CITY OF ALBUQUERQUE

May 15, 2019

Re: **GAHP INCA**
3701,3705, and 3711 Inca St. NE
Traffic Circulation Layout
Engineer's/Architect's Stamp **05-13-19** (G21D044)

TRAFFIC CIRCULATION LAYOUT

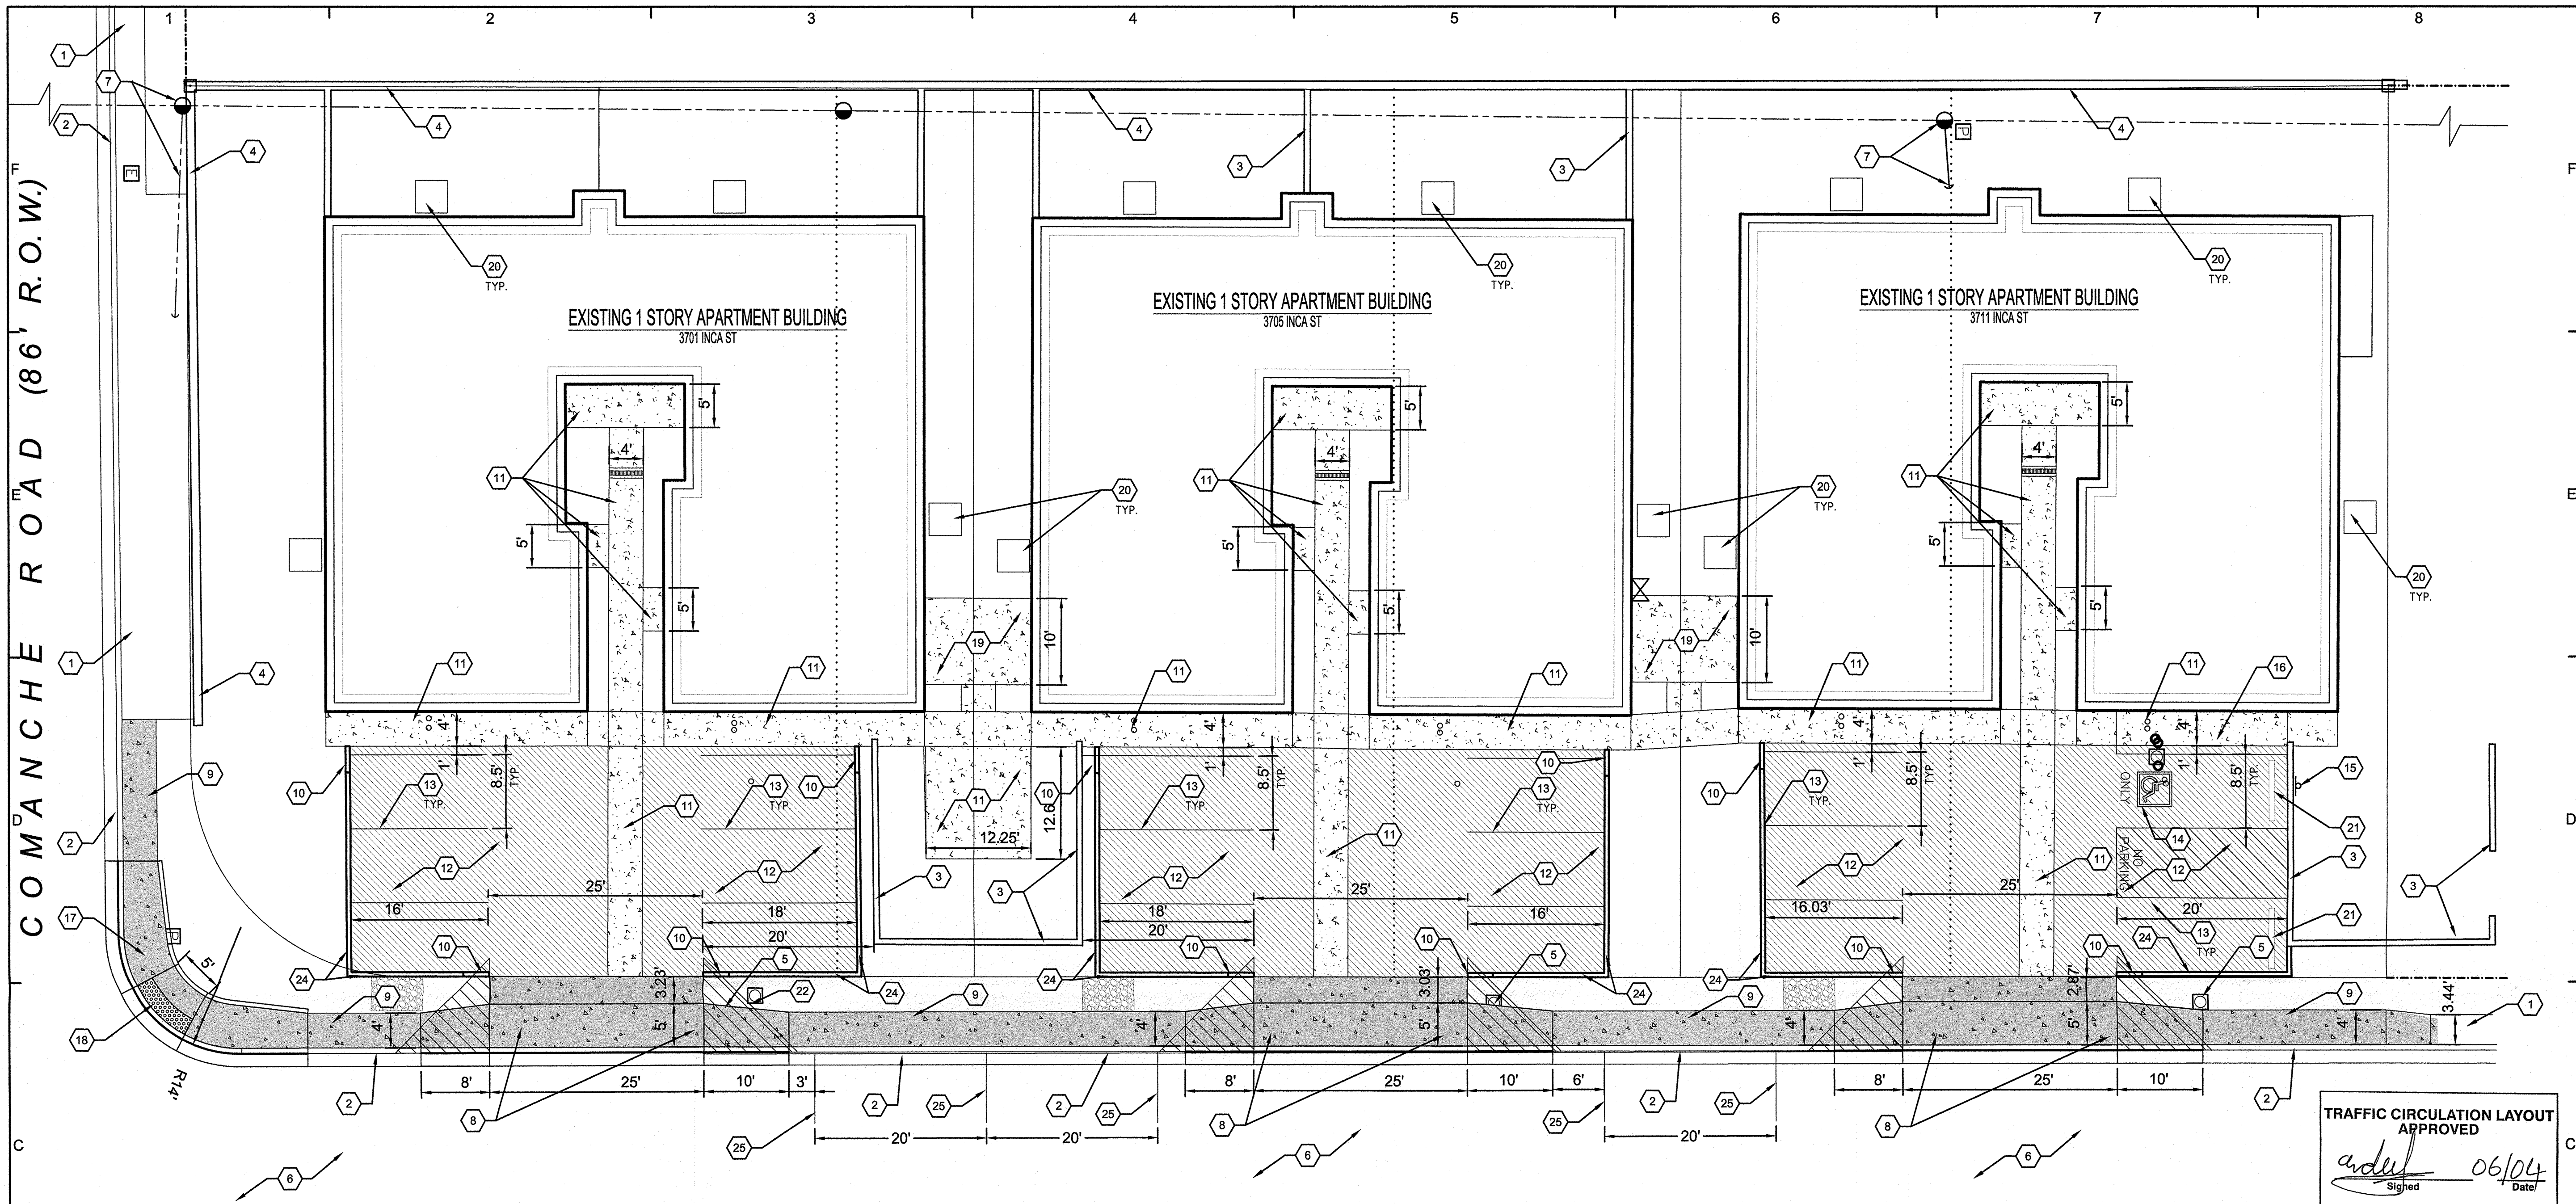
1. The handicap accessible spaces must include an access aisle. Van accessible aisles should be 8ft wide; all others should be 5ft wide. Also needs to be striped.
2. The ADA access aisles shall have the words "**NO PARKING**" in capital letters, each of which shall be at least one foot high and at least two inches wide, placed at the rear of the parking space so as to be close to where an adjacent vehicle's rear tire would be placed. (66-1-4.1.B NMSA 1978)
3. Please remove the asphalt removing section "10" from TCL. That part requires a mini work order.
4. For keyed note # 8 please use NMDOT standard.
